DECISION DELEGATED TO HEAD OF PLANNING

Application No: H16-1349-21 **Applicant:** Cley Developments Ltd.

Proposal: Erection of 2 two bed detached dwellings

Location: Land Adj. The Library Victoria Street Spalding

Drawing Title
GROUND FLOOR PLAN
& ELEVATIONS

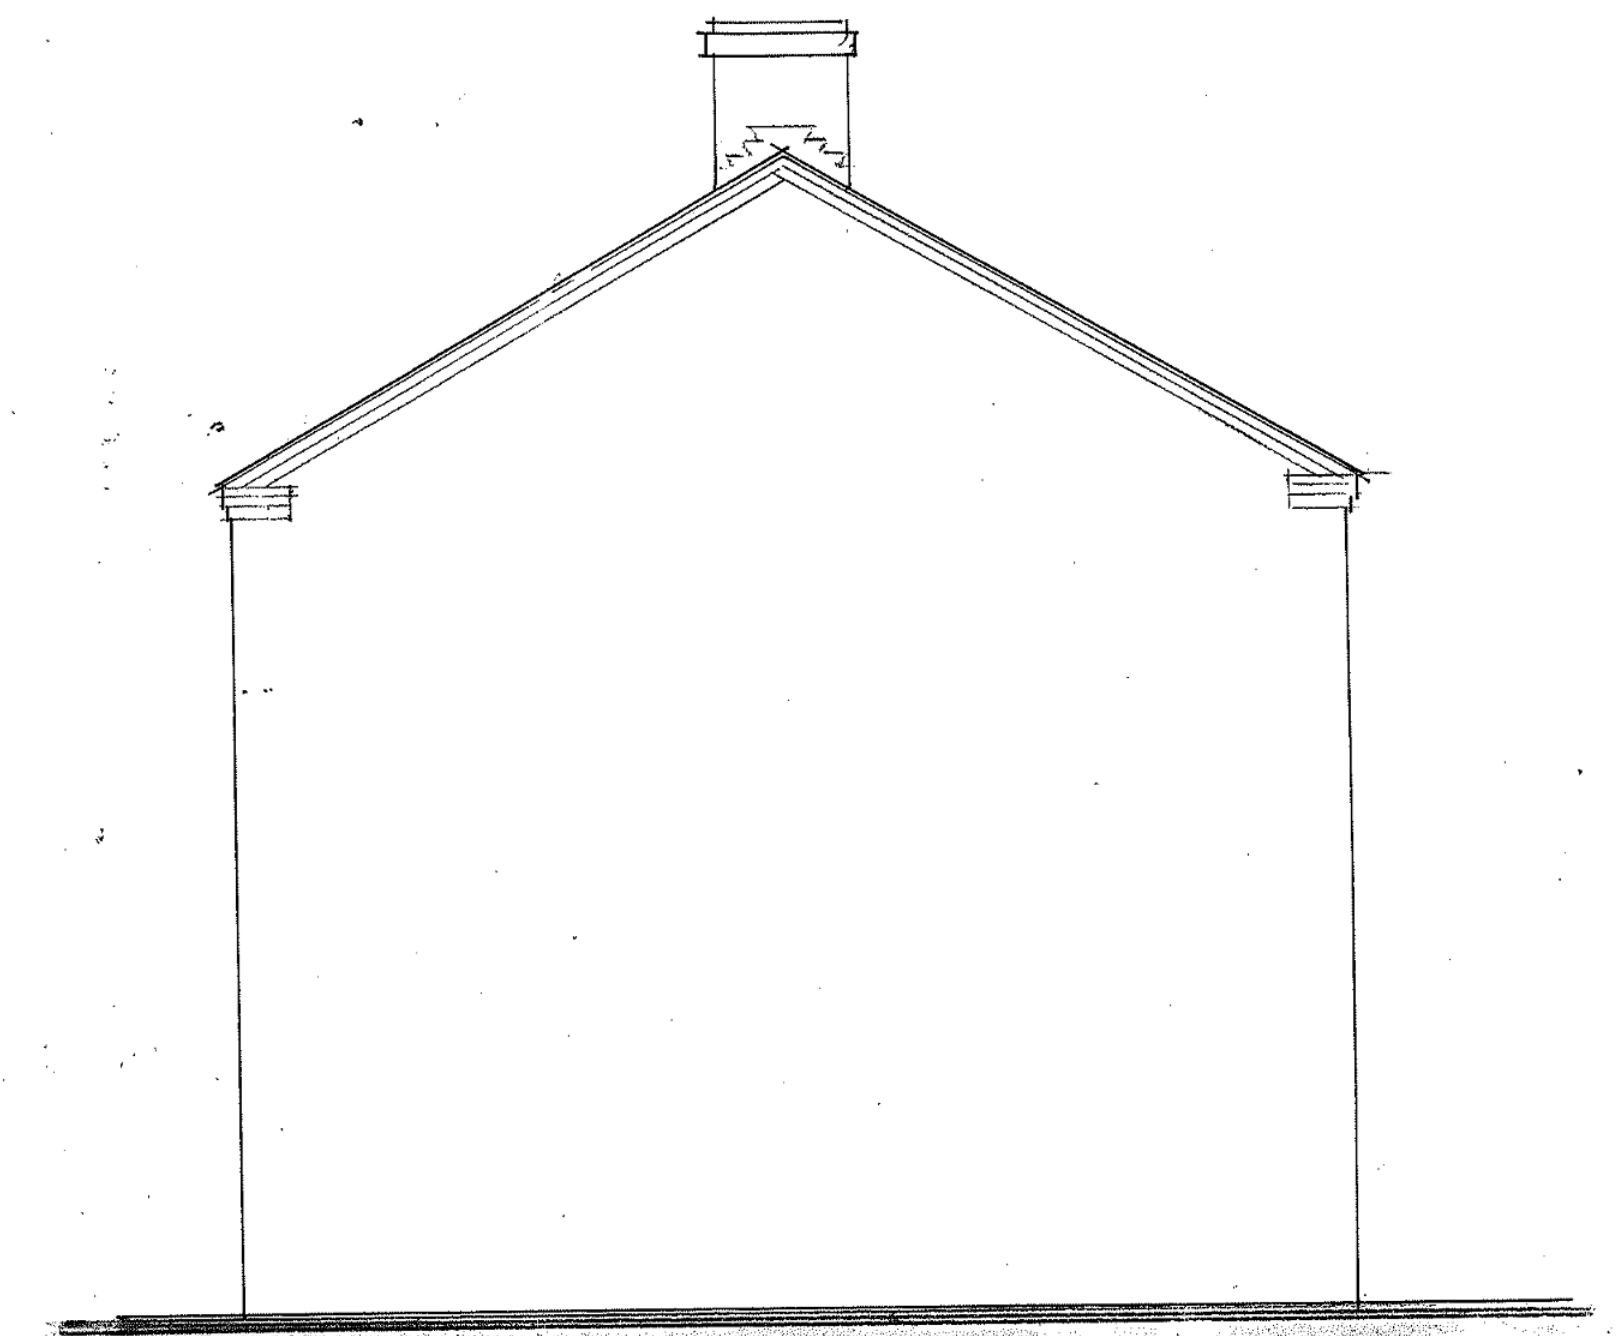
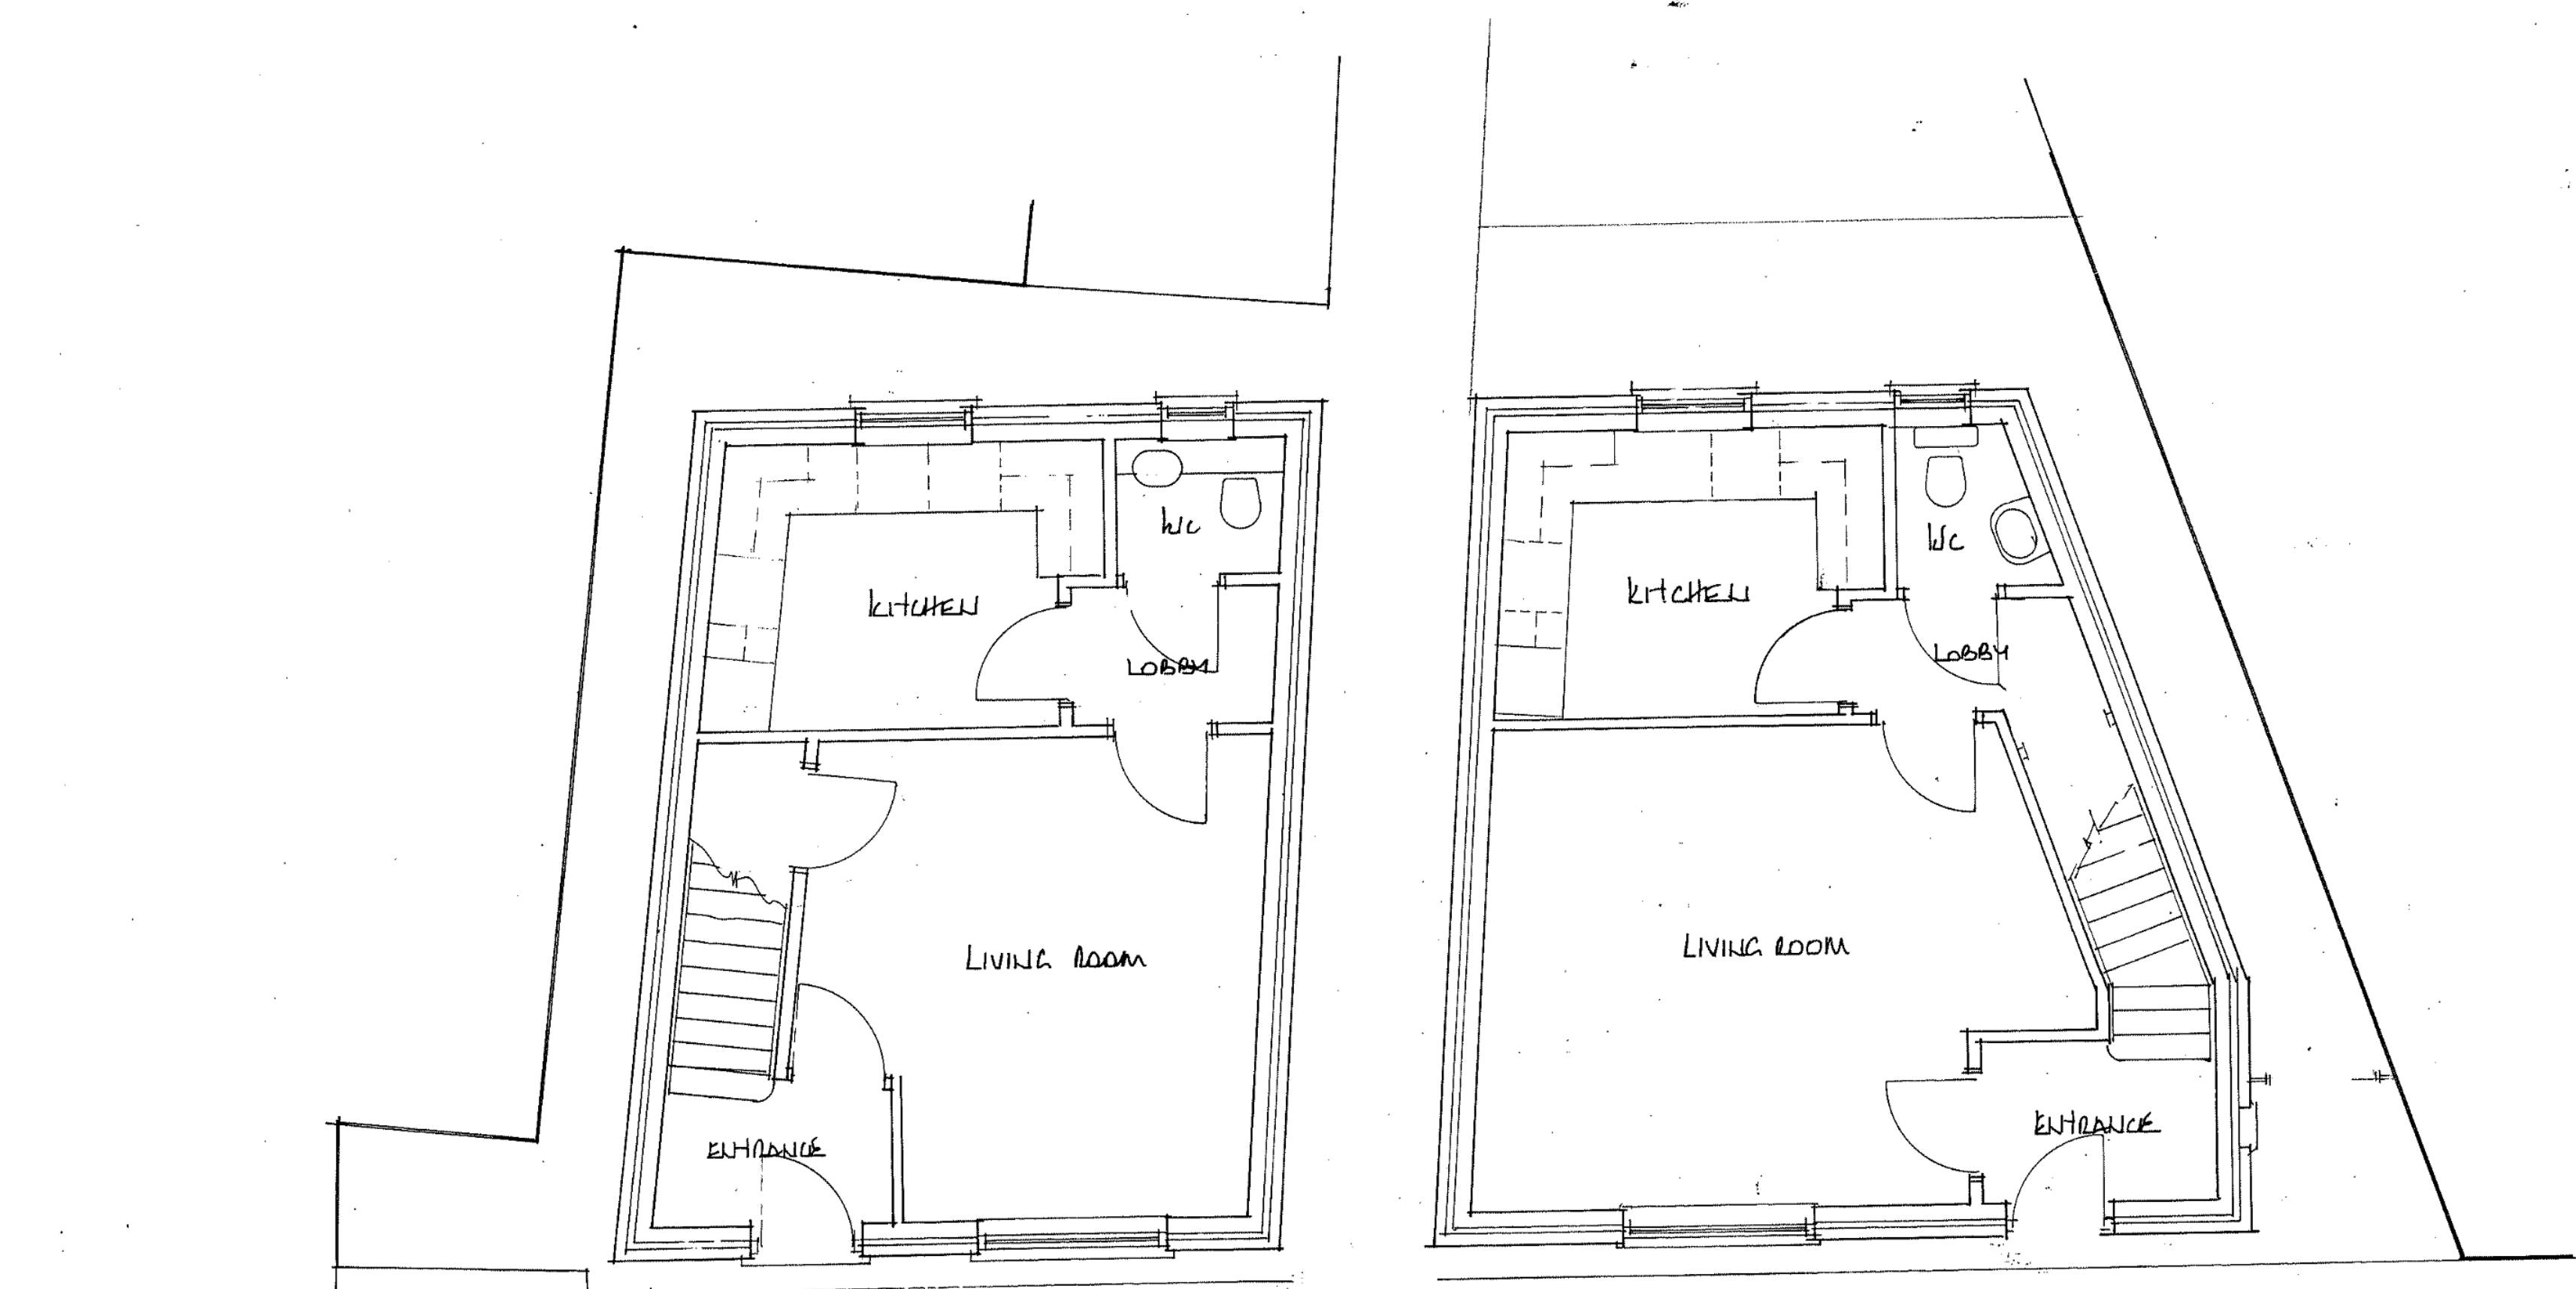
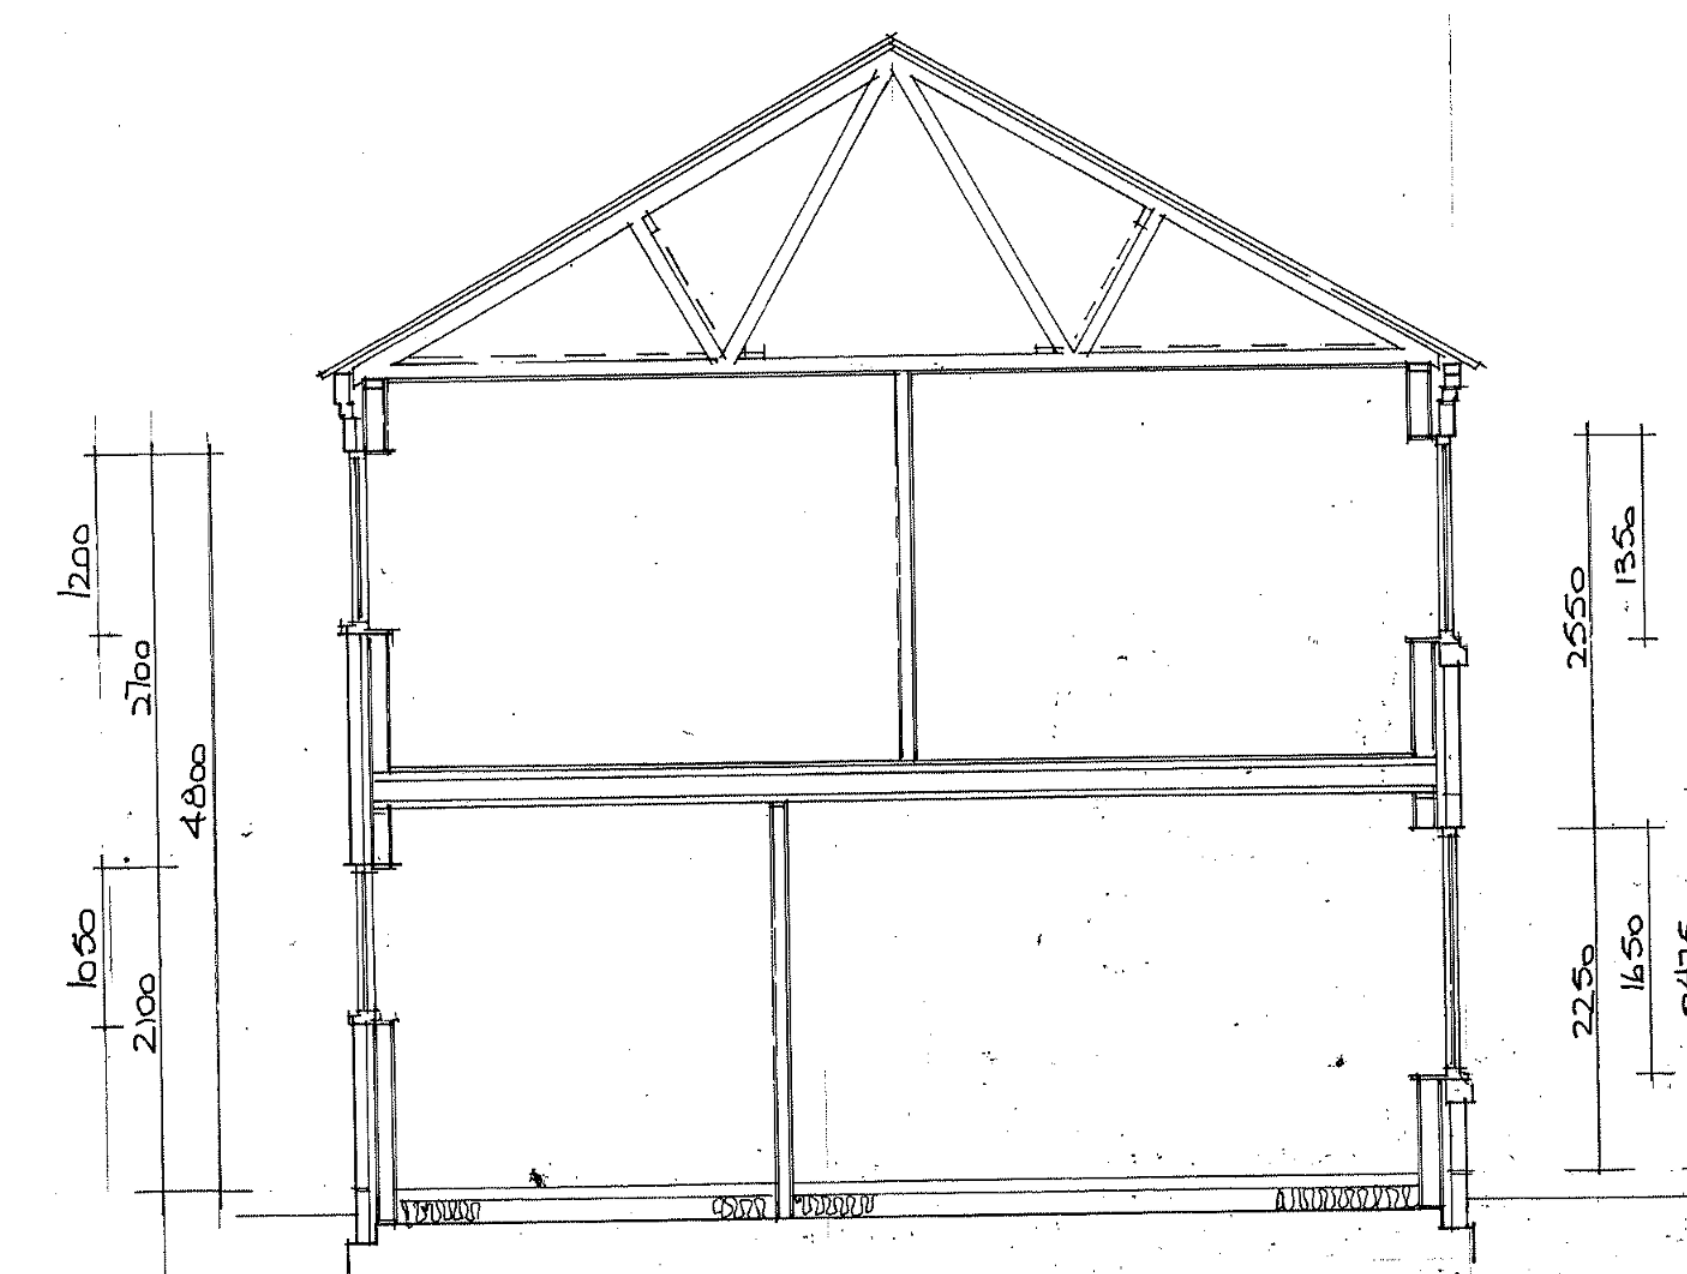
One objection - Pedals - The application plans do not show how the cycle storage referred to on the application form will be provided. This objection will be overcome if the plans are amended to show satisfactory compliance with Policy 36 and Appendix 6 of the Local Plan.

Cycle storage storage is indicated in the application form, but not shown on the plans. This is to be dealt with via a condition.

The Flood Risk Assessment submitted to support this application sets an expectation that the finished floor levels of the ground floors of these dwellings is set at 200mm above the footpath level of approximately 5.25 OD. This can be delivered via condition.
